From: Michael Eastham
Sent: 01 November 2018 14:53
To: Planning.Responses
Subject: FW: A/81/18/RES

From: Mark Warwick
Sent: 01 November 2018 14:51
To: Michael Eastham
Subject: A/81/18/RES

I have considered the latest Proposed Site Layout, dwg no: Ang101 Rev O - the only substantive submission with potential to affect the ongoing health and vitality of retained trees, since I last commented (see previous report, August 9th).

Job No. 1006	Drg No. Ang101	Rev: O
Scale: 1:200 @ A1	Drawn: GC	
Date: May 2018	Check:

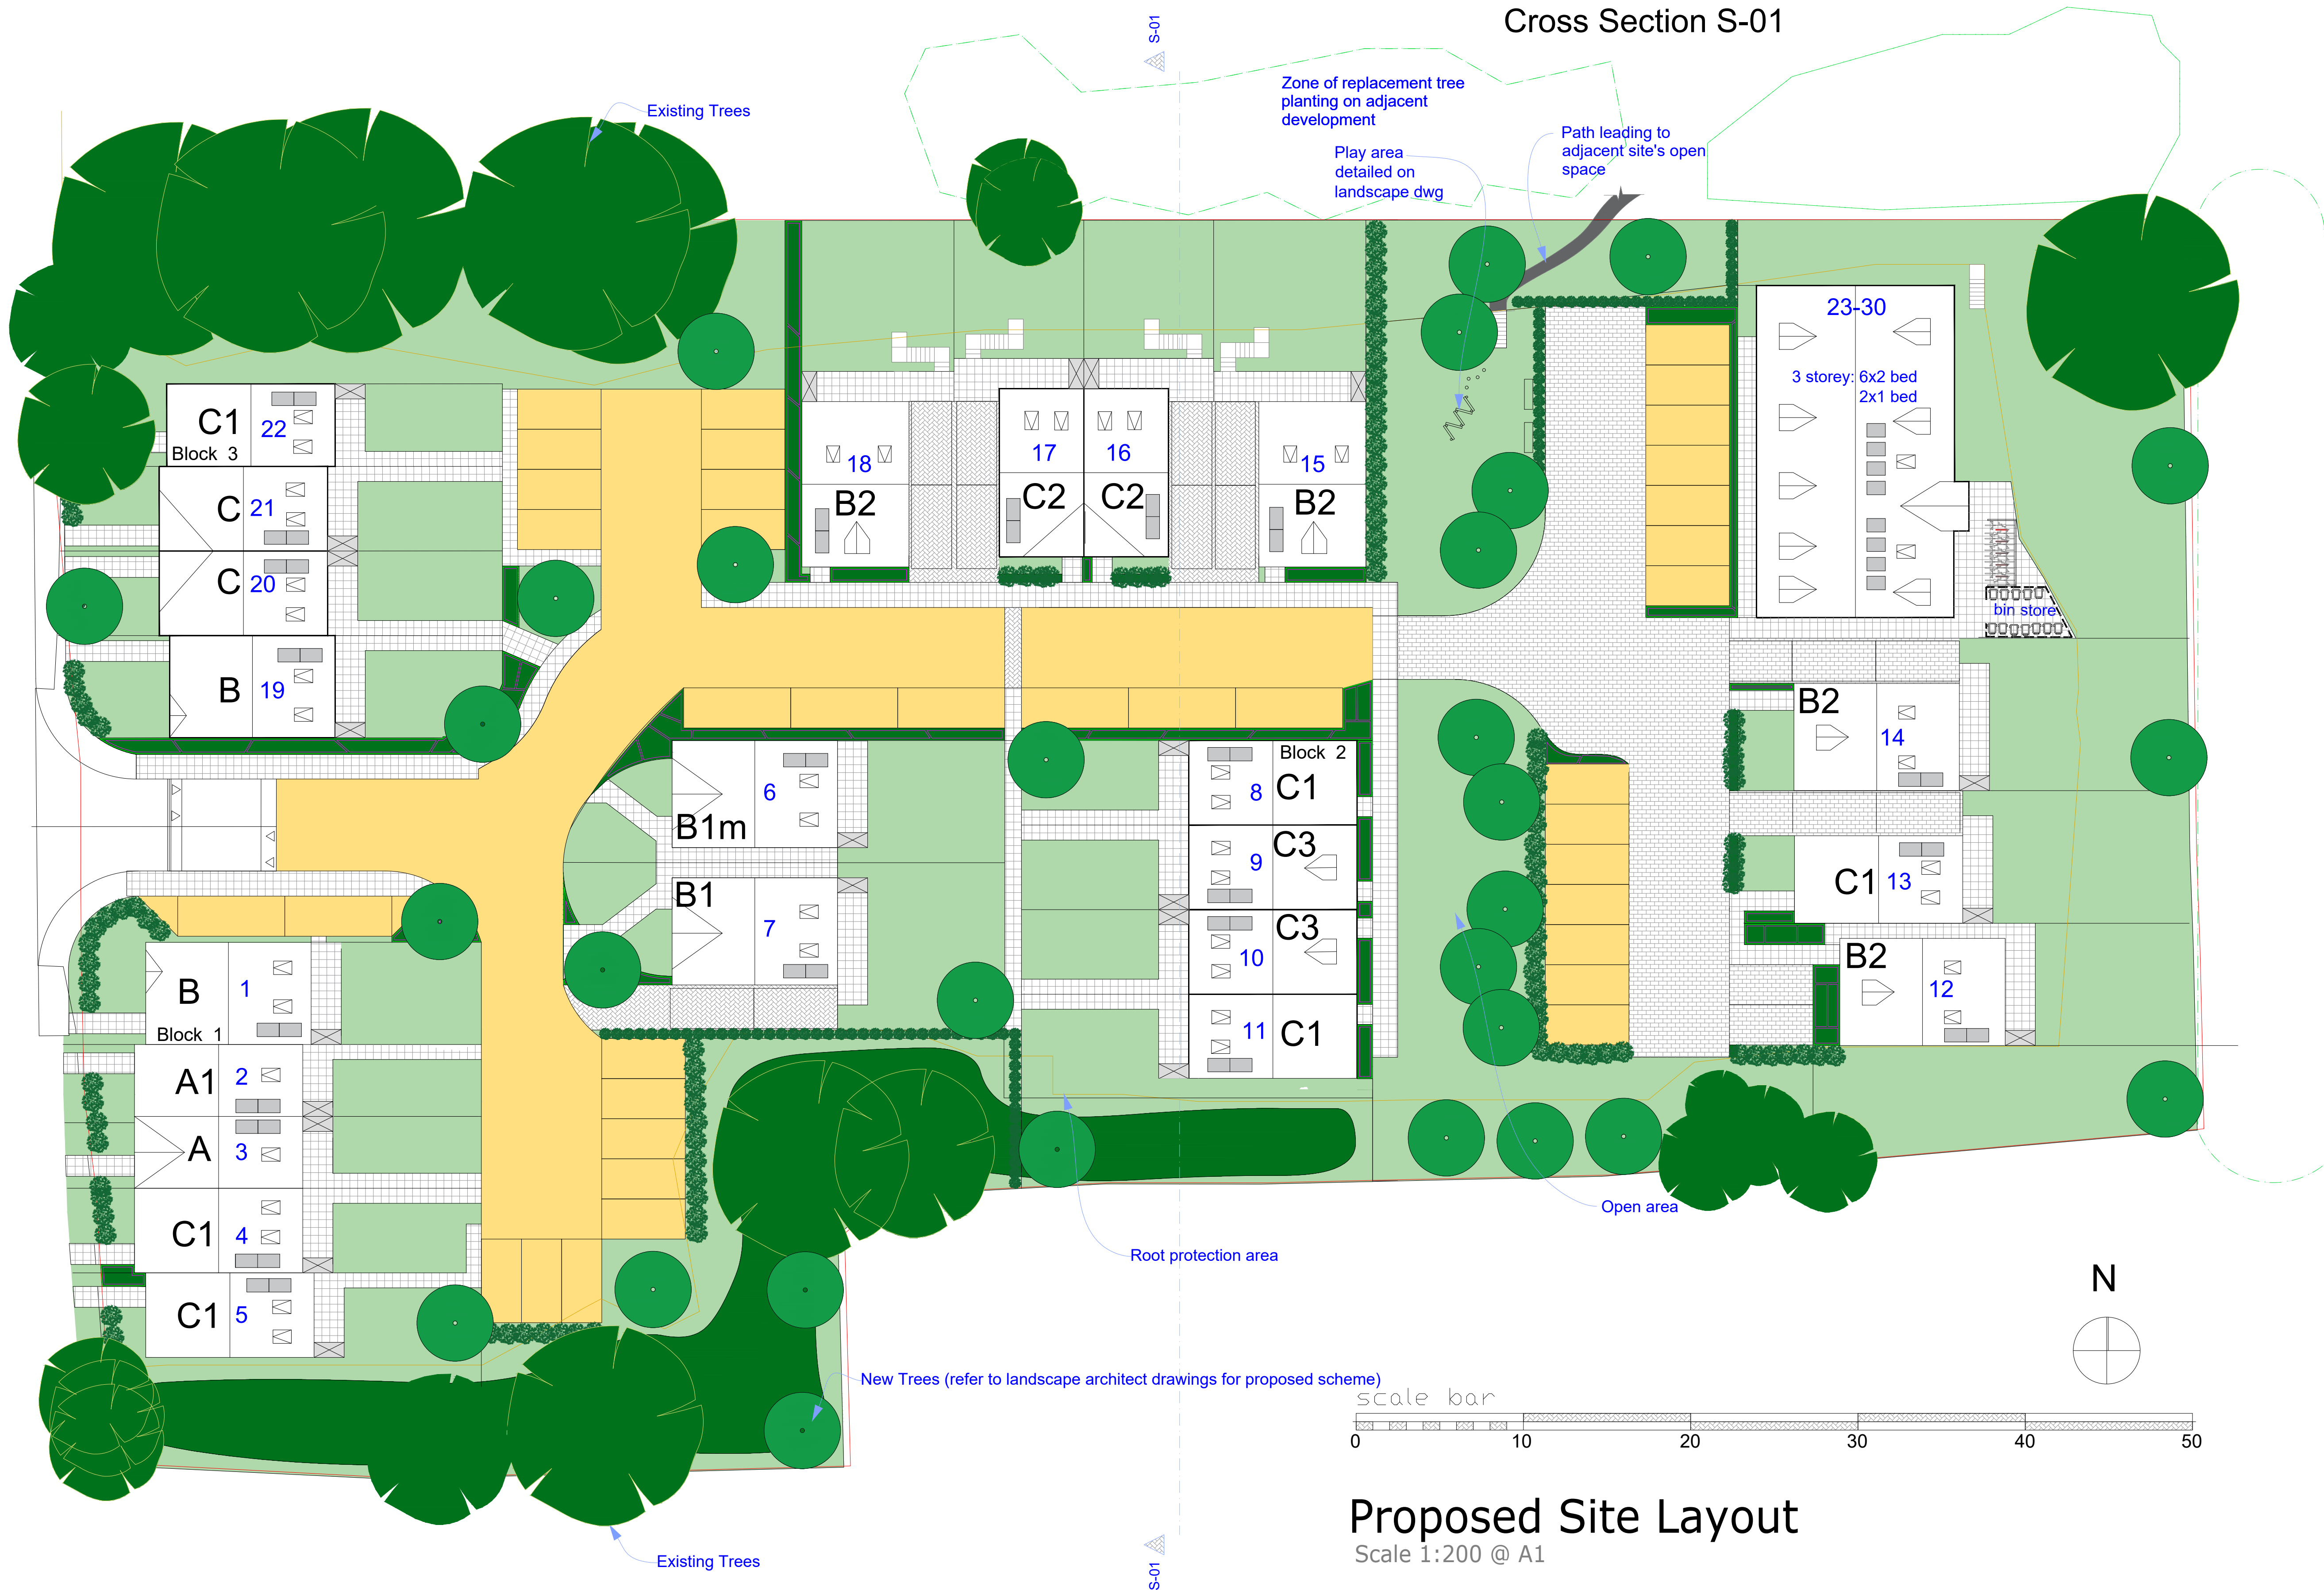
While thankfully the new layout does not attempt to impact further on the retained tree population; it does not allow for the retention of a greater number of trees and therefore I am unable to provide further comments of substance or remove my Objection in principle.
